CITY OF ALBUQUERQUE

Re: Carlisle and Menaul
Traffic Impact Study (H16D083F)
Submittal dated May 29, 2025
Via email cvermillion@bhinc.com and ABQ-PLAN

Required infrastructure improvements per the Study include:

**SITE PLAN AND CROSS SECTION
EXHIBIT**

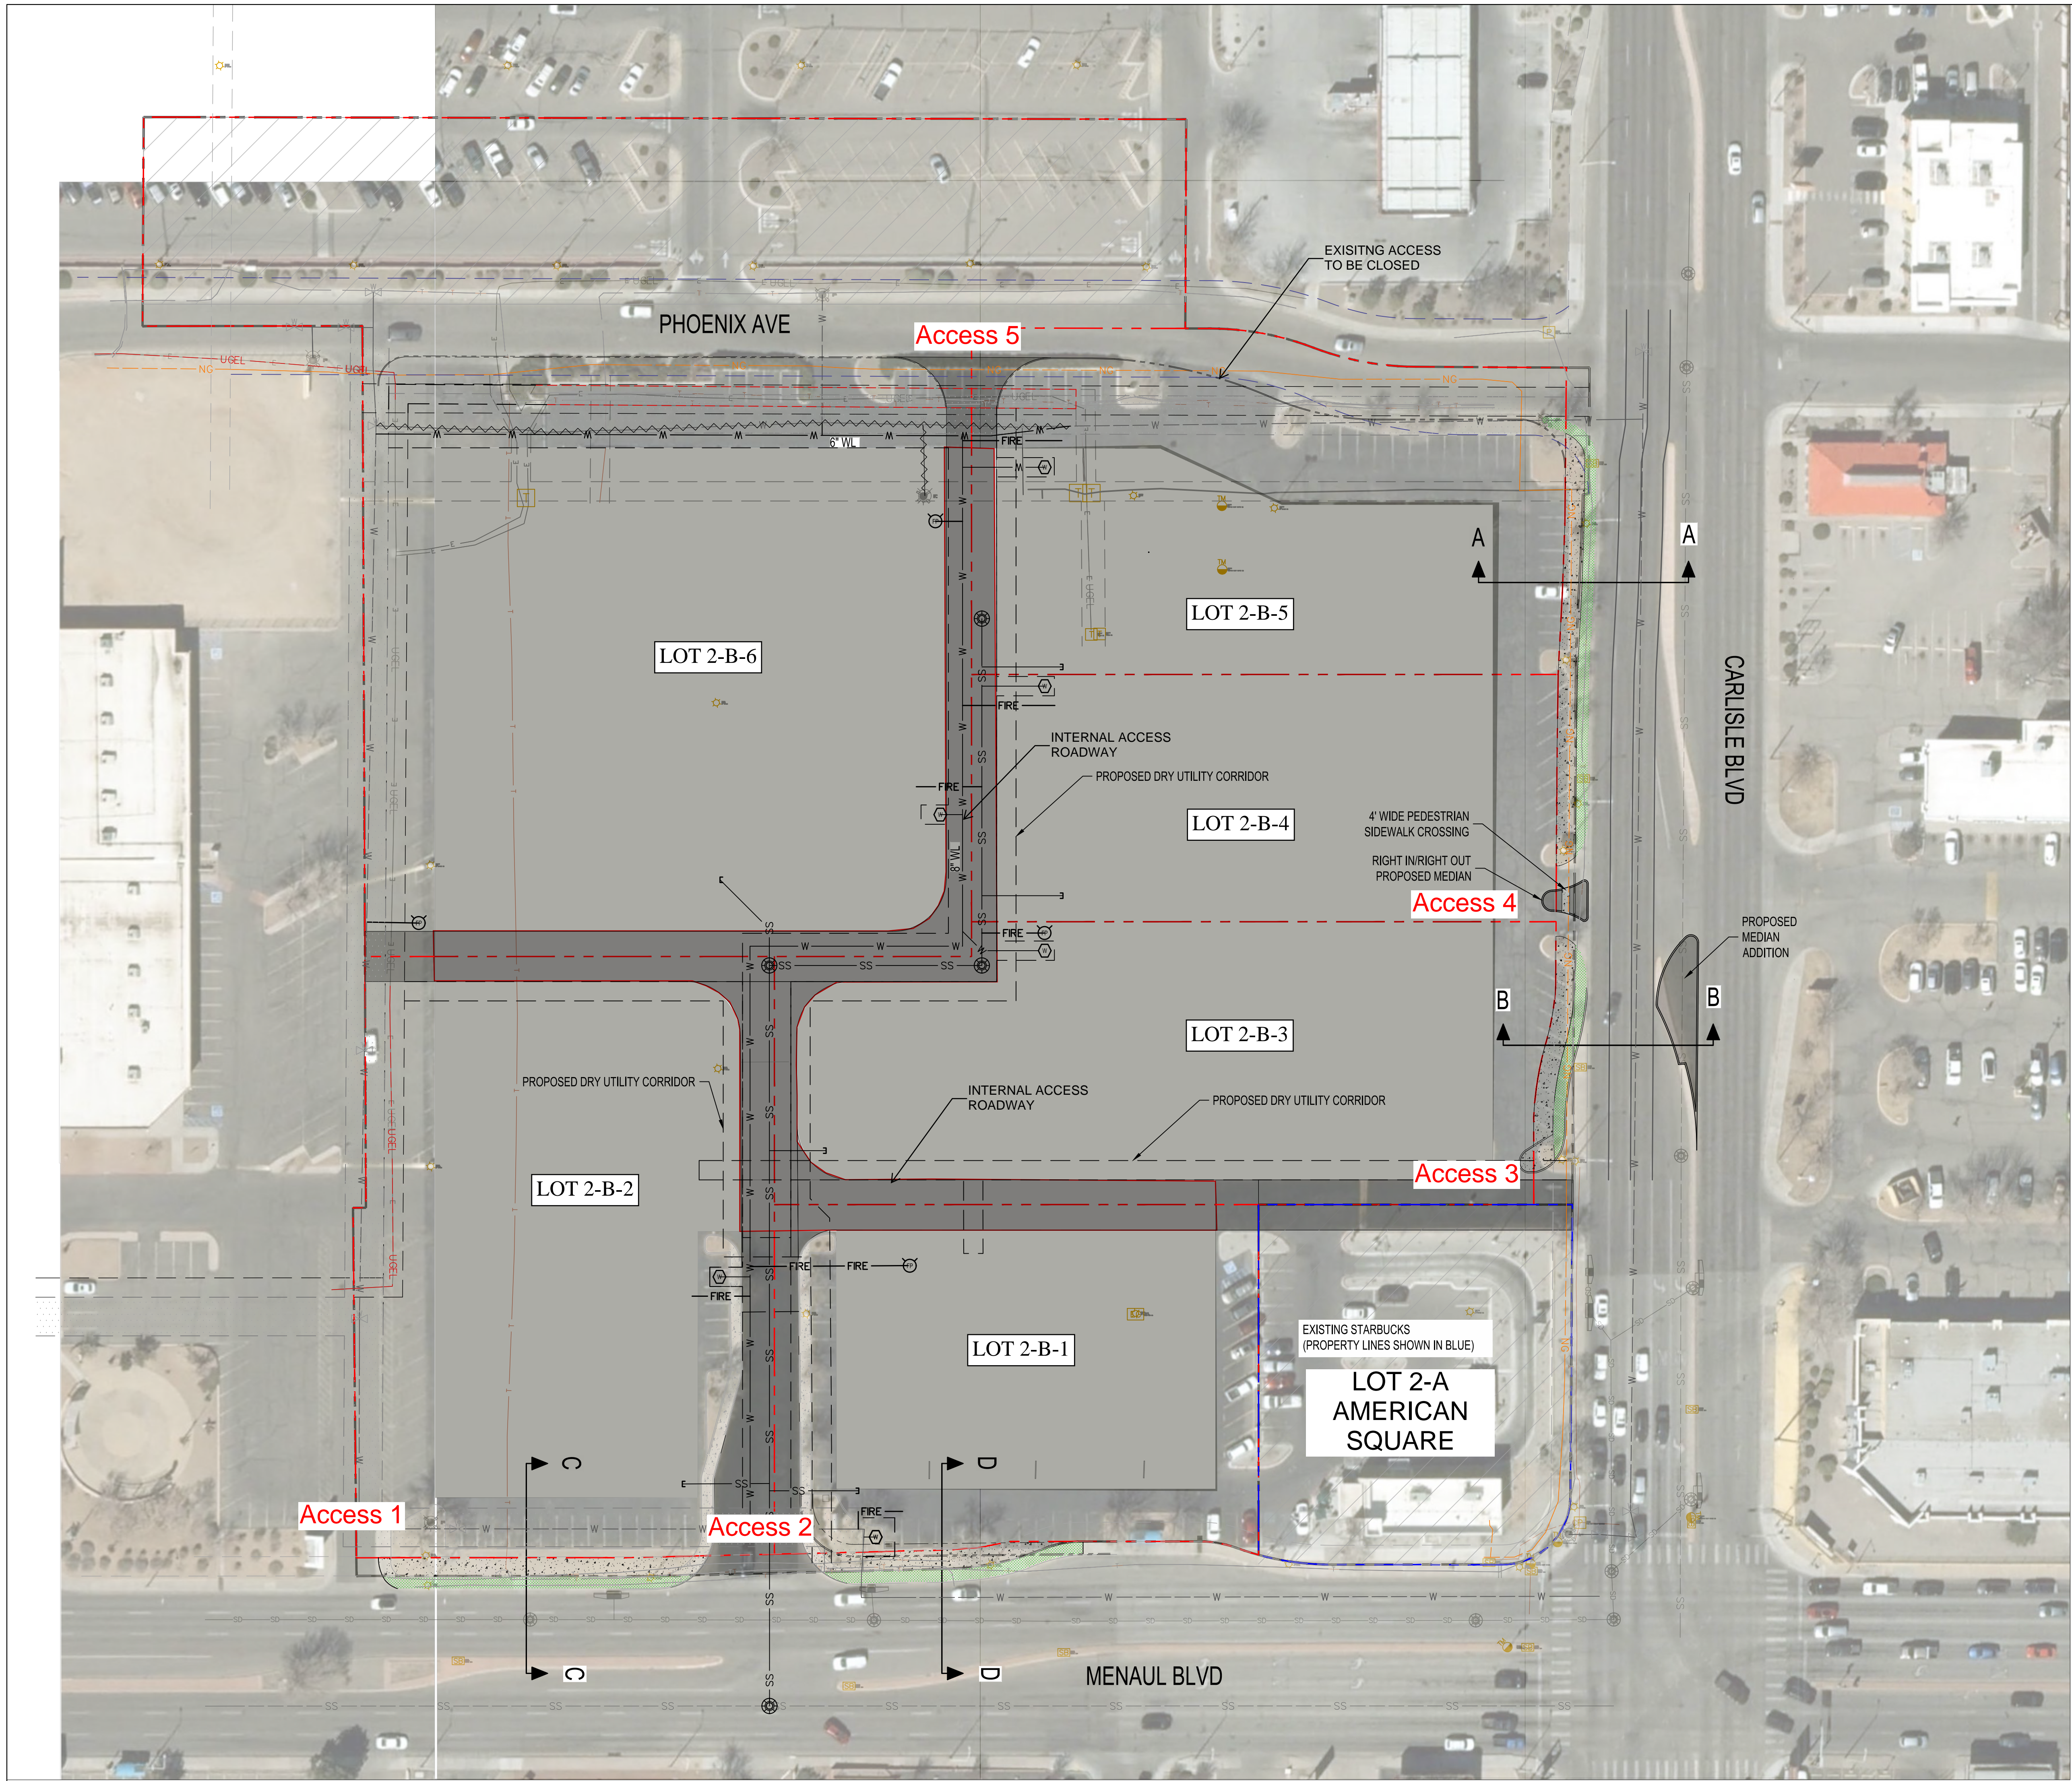
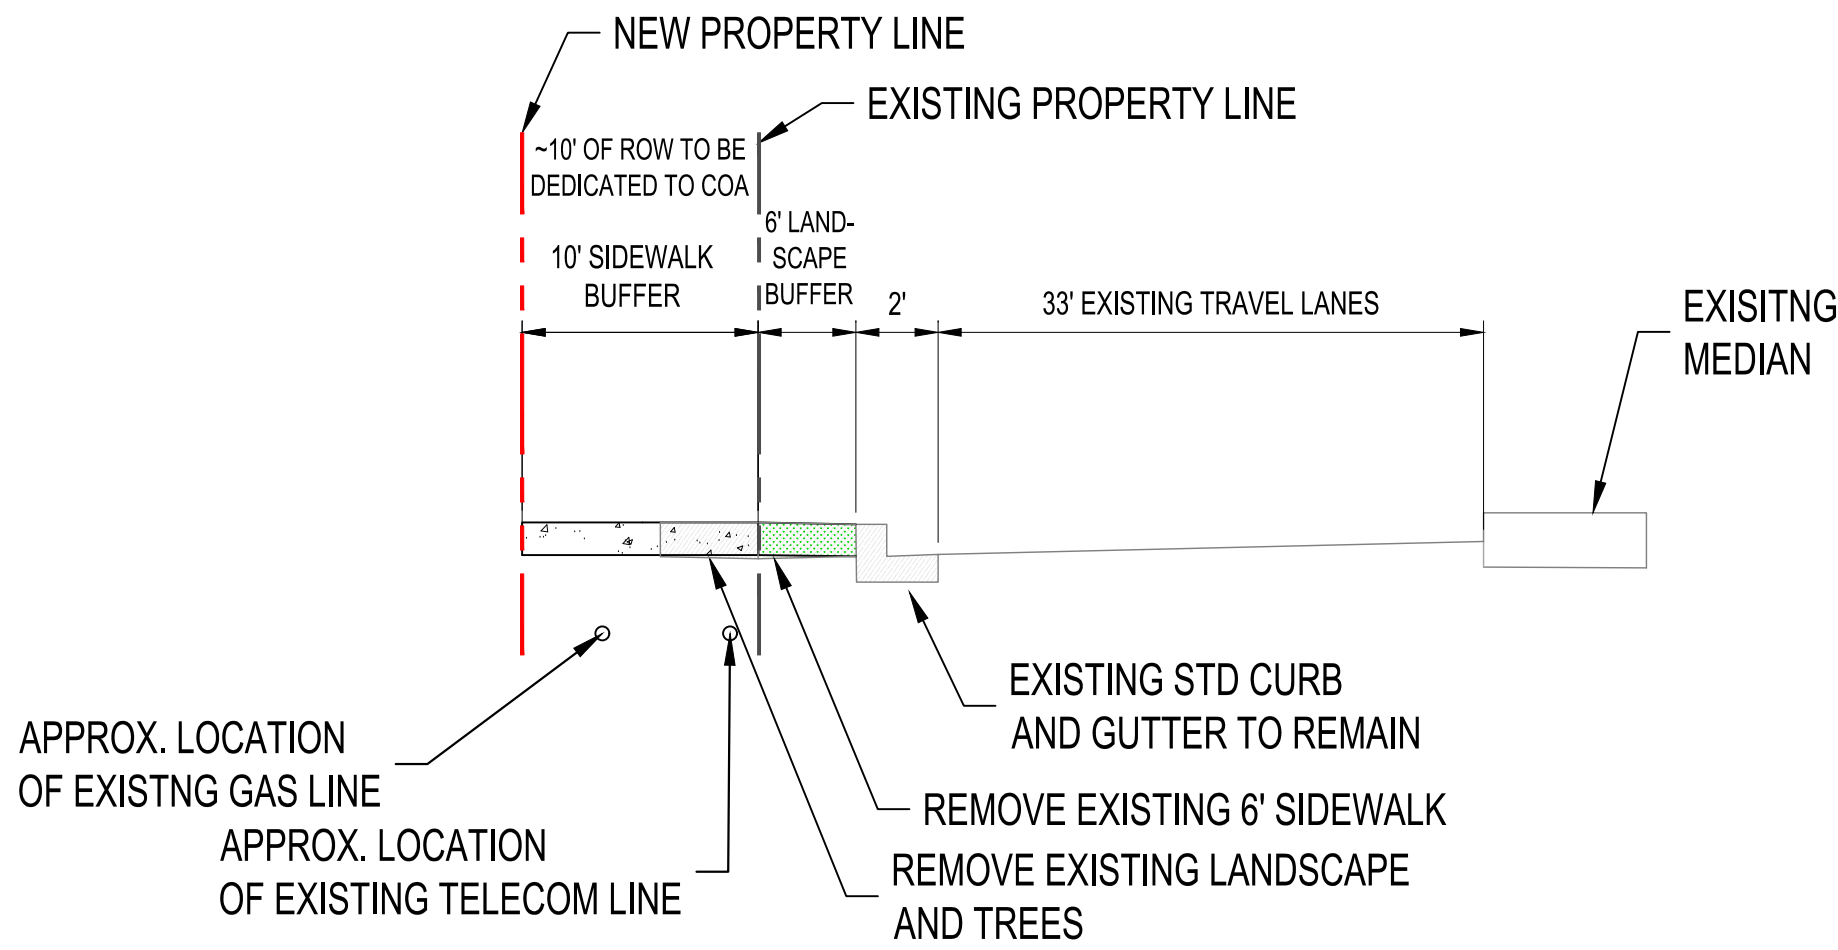
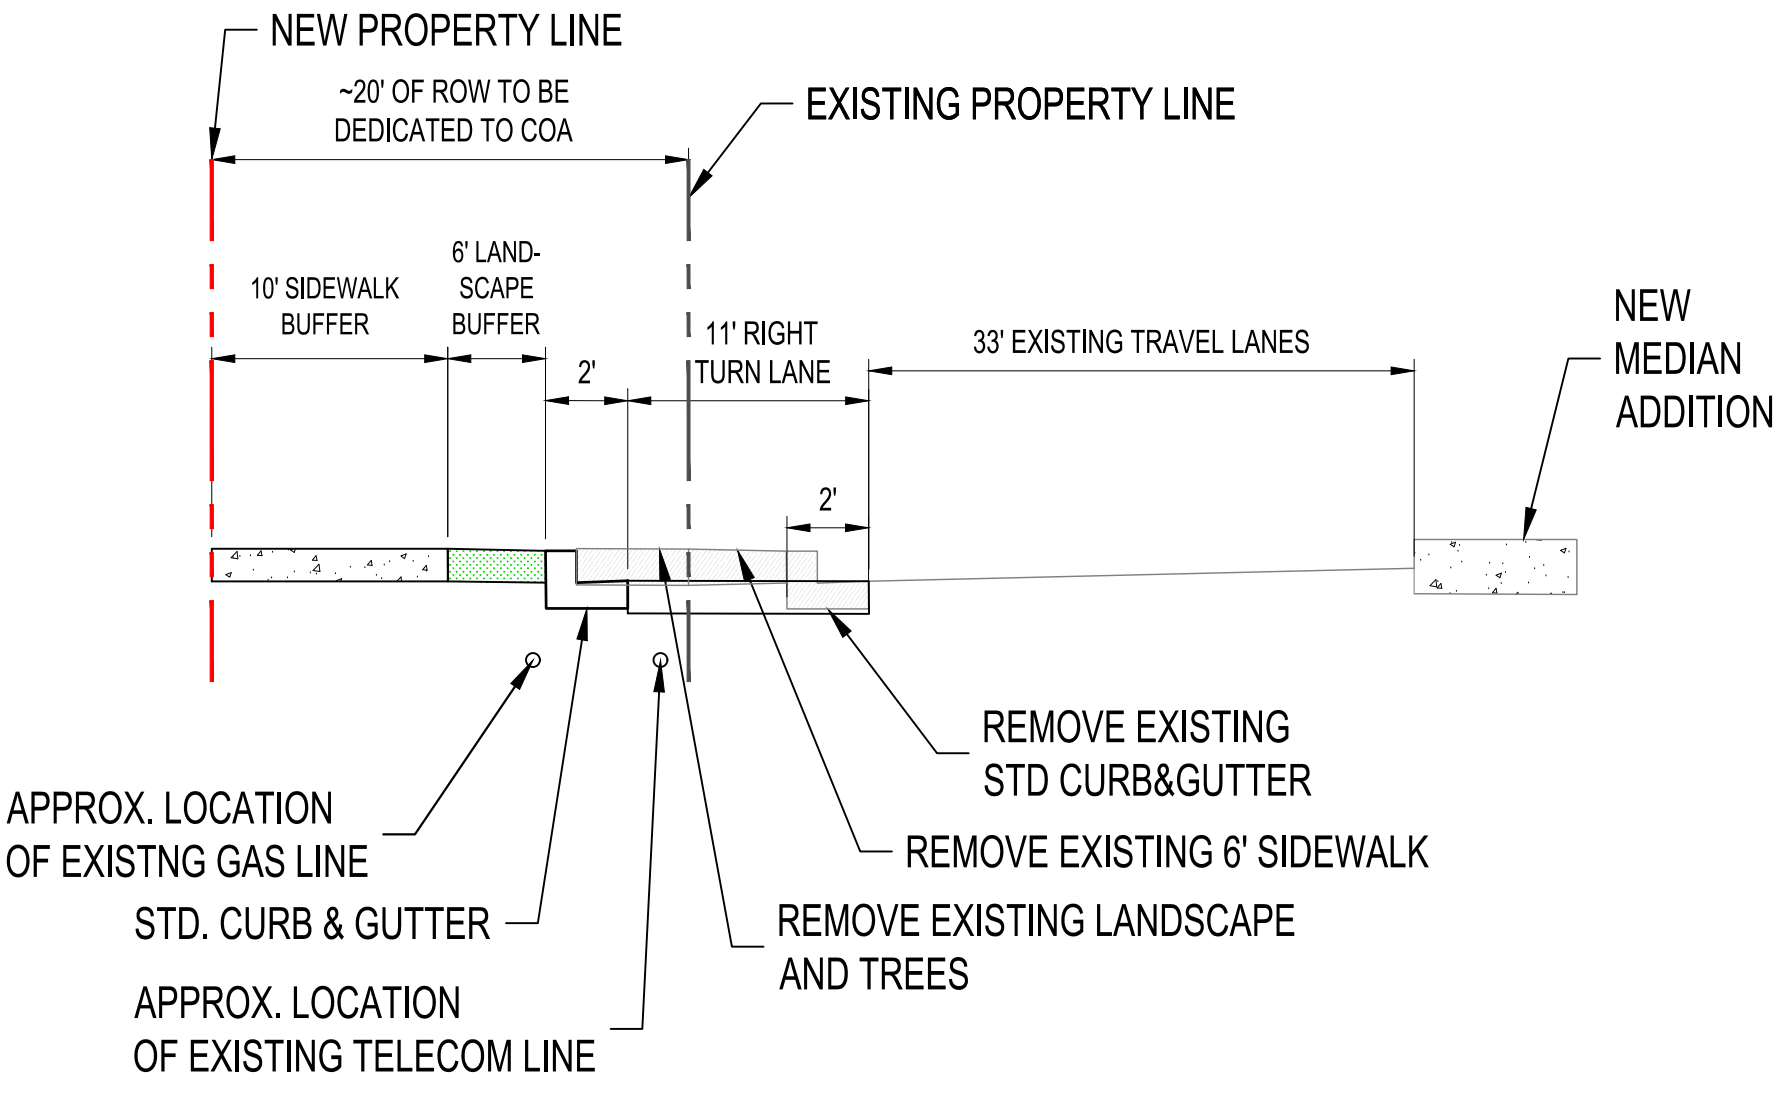
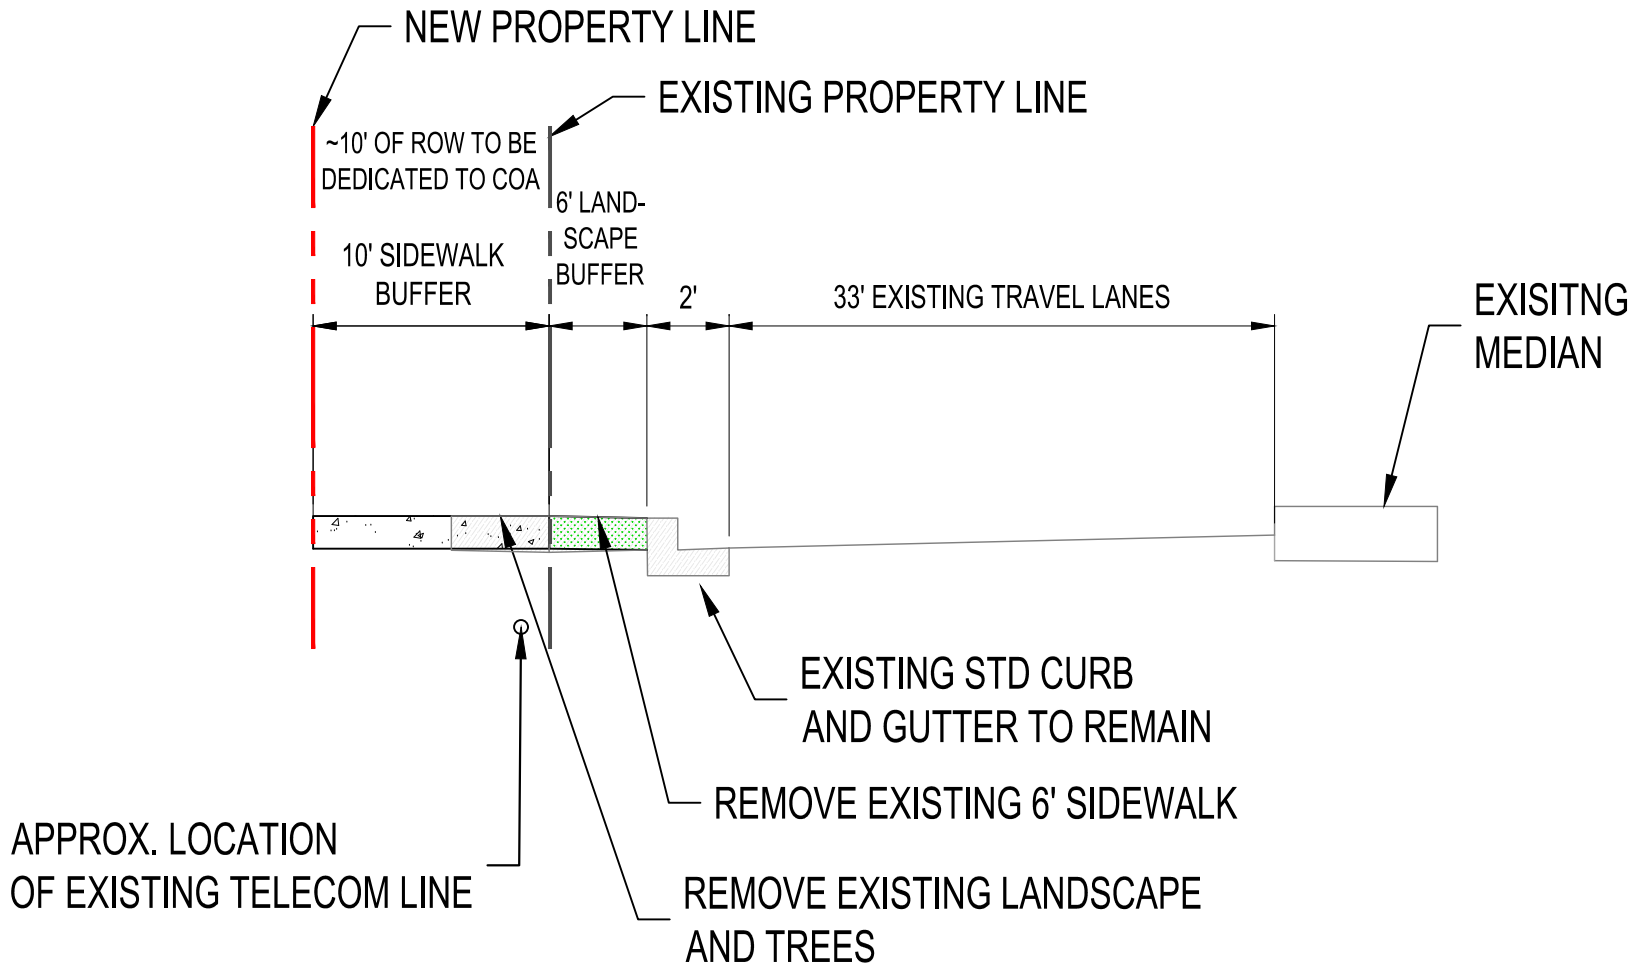
1. Carlisle and Menaul intersection signal timing adjustment to have all movements operate at LOS D or better. Coordinate with Traffic Operations.
2. Access 4 on Carlisle to be redesigned to a single exiting lane with only eastbound right out and south bound right in. Northbound left out to be removed and directional island installed. Also, the median on Carlisle to be modified to eliminate left in movement. New signage to be installed showing no left turns.
3. Access 1 on Menaul to include new one-way sign (R6-1-36) in the median to indicate right turn only.
4. Access 3 on Carlisle install right turn only pavement arrow. Paint median to increase median visibility.
5. All post construction signal optimization recommended in the study..
